From: Sarah Burrow
Sent: 23 December 2019 16:39
To: Planning.Responses
Cc: Amy Myer; Paul Cann
Subject: RE: Planning Consultation on BR/327/19/DOC

Engineers Comments Regarding Proposed Surface Water Drainage Design

APPLICATION NO: BR/327/19/DOC

Site Address: 283-285A Chichester Road Bognor Regis PO21 5AH

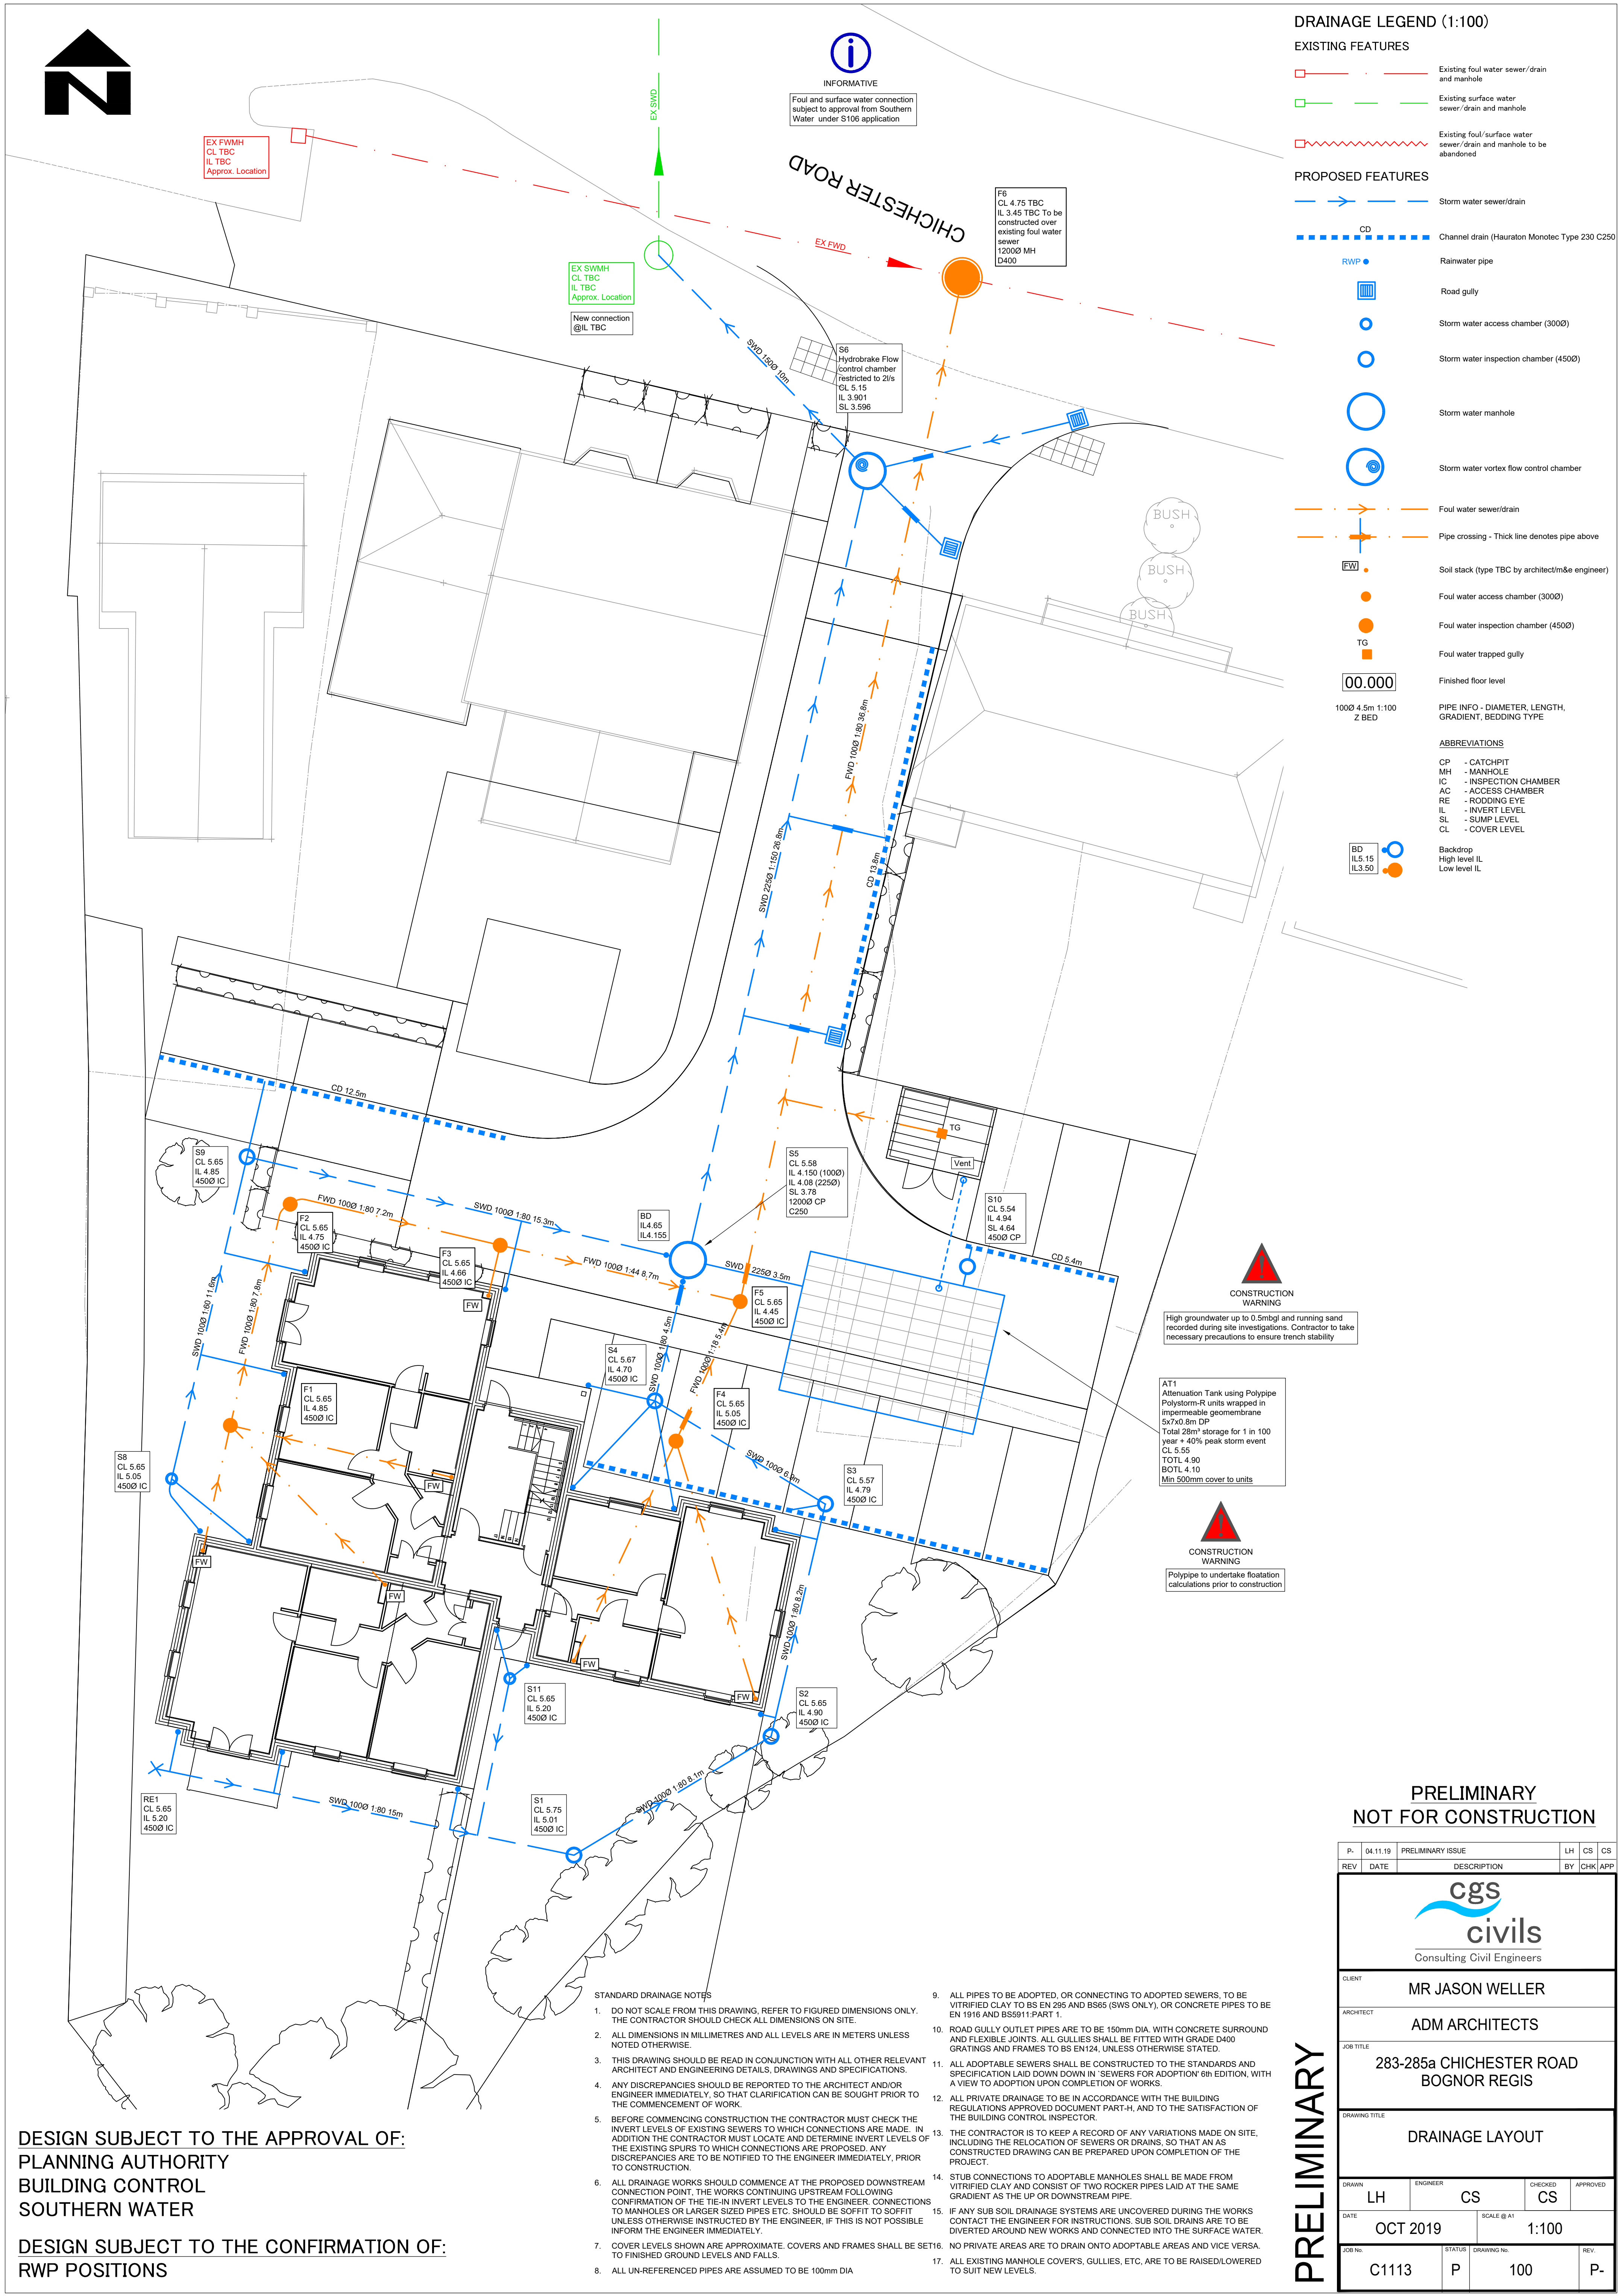
- 2: The proposed gully adjacent to Chichester Road is at a level of 4.7 with the 1 in 100 + 40% storm reaching levels of 4.974 at the Hydrobrake flow control chamber. Please provide evidence that this gully will not flood in a 1 in 100 + 40% storm or alternatively adjust the design to ensure that this is avoided.

- 3: Please detail cover types (loading class) on all manholes.
- 4: Pipes are shown entering the attenuation tank at the base. Please raise the incoming pipes (or lower the tank) as much as possible. The minimum cover to units should be 650mm as the tank is under a road surface. Specify invert level/pipe diameter of incoming pipe and specify outgoing pipe invert level. It is assumed that the 225mm diameter outlet pipe is being laid flat to allow bi-directional flow – please make clear on drawing.

- 5: Hydrobrake detail states “restricting flows to 5l/s” – this should be 2l/s. The incoming pipe is labelled as 225diameter on the drainage layout, but 150 diameter on the detail. Specify more details on chamber ie. ring diameter, manhole cover, brickwork, sump dimensions, concrete surround thickness, base thickness & material, benching material, cover slab, rocker pipe length, etc

- 6: There does not appear to be a detail for catchpit manhole 5.
- 7: Provide backdrop construction detail.
- 8: Provide vent detail for tank.
- 9: Channel drain construction detail - specify channel dimensions. Incorporate sump on each channel drain outlet. Specify outlet pipe diameters/levels.

- 10: The road gully detail shows them being 1.8m deep – is this correct?
- 11: Connection detail pipe to pipe – remove square option and show as oblique. This detail needs to reflect connections of differing diameters too.

- 12: Specify invert level at the existing manhole being connected to, including proposed connection level. Specify existing pipe diameter being connected to. Did any part of the original site discharge to this manhole? Are there any other existing connections into this manhole? If so, please indicate. Confirm that this system connects into the main public surface water sewer in Chichester Road and not the foul sewerage system. Provide CCTV survey of pipeline

between the existing manhole and its connection to the main public surface water sewer, to ensure that it is fit for purpose. Depending on your findings, then this pipeline may be classified as a public sewer under the 2011 legislation. If this is the case, we will need to see confirmation from Southern Water that the connection is acceptable.

13: Manhole upstream of tank –provide catchpit inspection chamber construction detail (S10).

14: S3 to S4 – specify pipe gradient.

15: Indicate proposed pipe materials on plan.

16: Pipe bedding – concrete bed and surround required where less than 1.2m cover in vehicular areas. Amend details and provide detail of expansion joints that are required where pipes receive concrete protection.
